State Significant Development 7664

Horsley Drive Business Park Stage 2
Section 4.55(2) Modification Application

Submitted to Department of Planning, Industry
and Environment
On behalf of Charter Hall

17 June 2020 | 2190880

Figure 8 Overall Site Plan

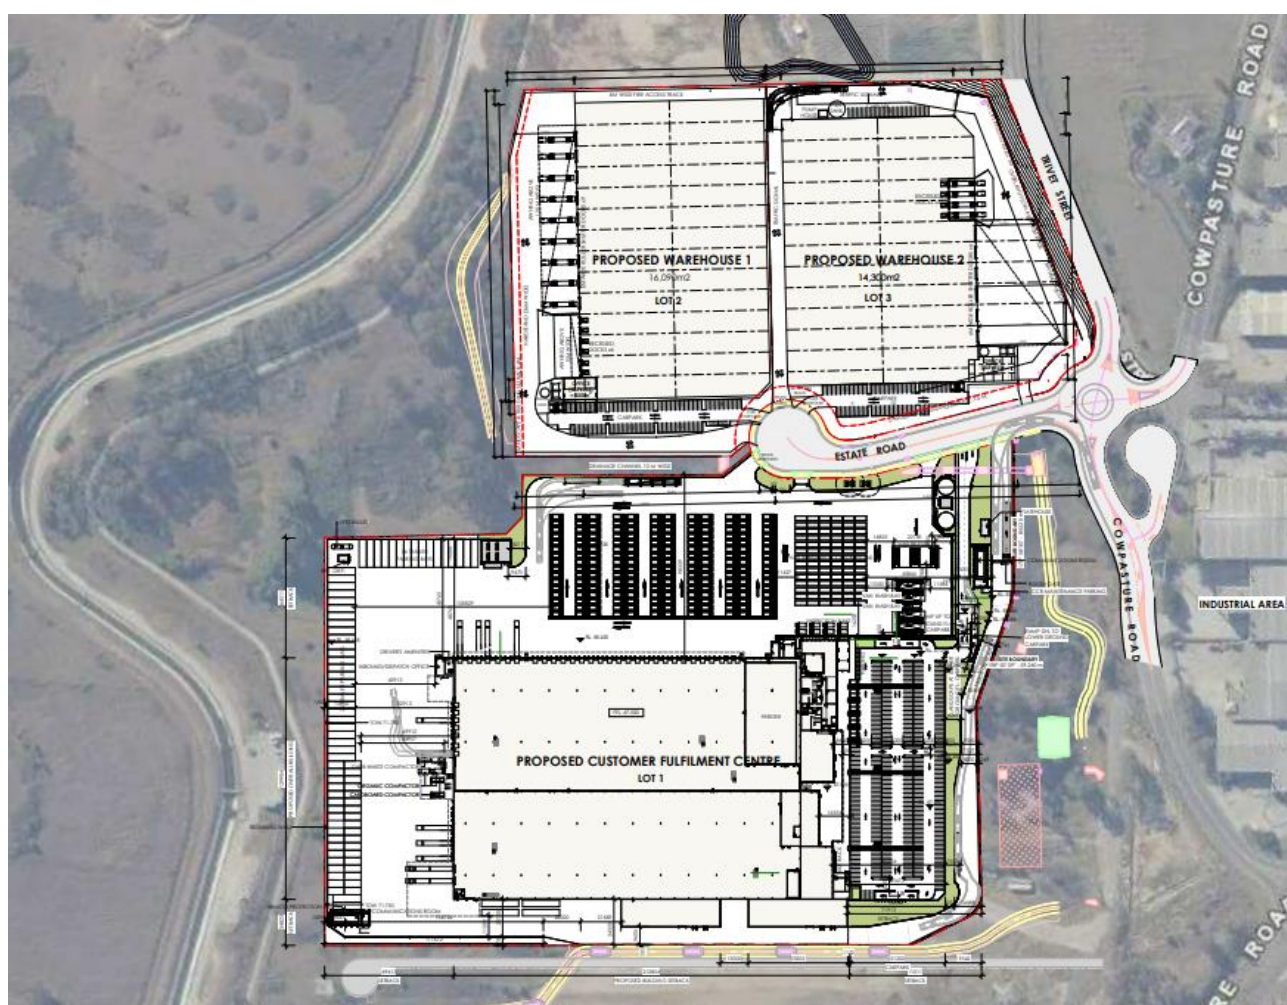
3. *an amended site plan which clearly illustrates for example existing lot boundaries, topographic contours, lot sizes, building envelopes, easements, existing infrastructure.*

An amended site plan is attached at **Appendix B** that correctly identifies all relevant lots that formed the site area under the Concept Approval for SSD 7664 (Lots 17-22 DP 13961 and Lot 2 DP 1212087).

The lot boundaries, easements, building envelopes and existing infrastructure are all clearly shown on amended overall site plan drawing (DA02).
